### **Mowbray Road, Lane Cove North, Affordable Housing**

SSD-71687208

I emphatically oppose the proposed development at 618-624 Mowbray Rd & 25-29 Mindarie Street Lane Cove North. The development application is entirely inadequate, missing vital information about the strategic planning context for the precinct and generally doesn't address the environmental and social impact of the development on the local community.

Figure 14: Shadow diagrams based on the proposed development (at winter solstice)

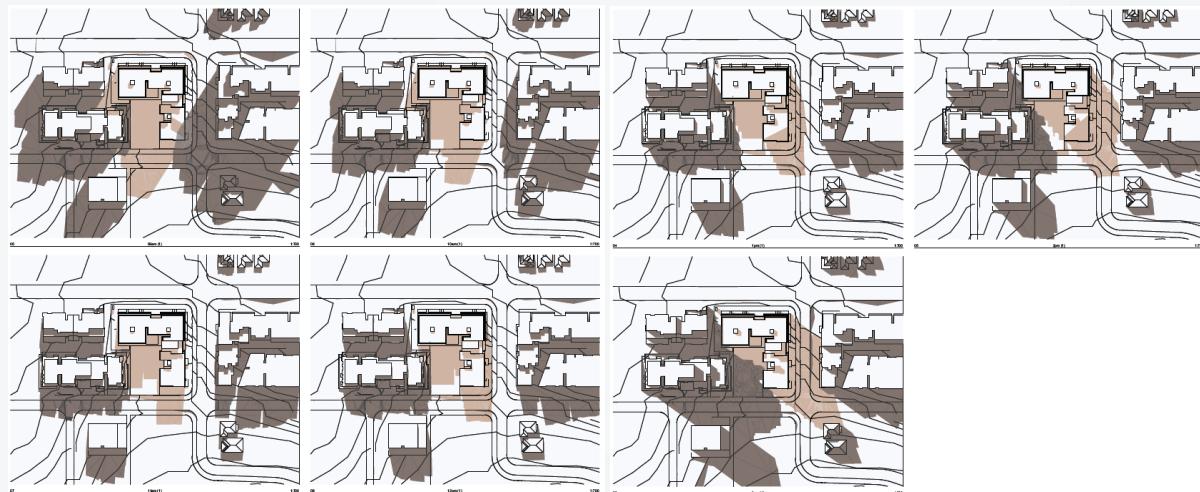
The height of the building also towers above the Mindarie Street playground, which has been obscured from the photo. The EIS clearly shows overshadowing of the playground in winter, however the EIS states the “overshadowing impact to Mindarie Park is not considered unreasonable as it does not affect any of the key recreation spaces and playground areas of the park”. (EIS p73). This is not correct, the diagrams clearly show the development will overshadow the western end of the children’s playground. Overshadowing the playground is unacceptable. There is no evidence the applicant has considered lowering the building height or increasing the setbacks to the upper floor(s) to reduce these impacts.
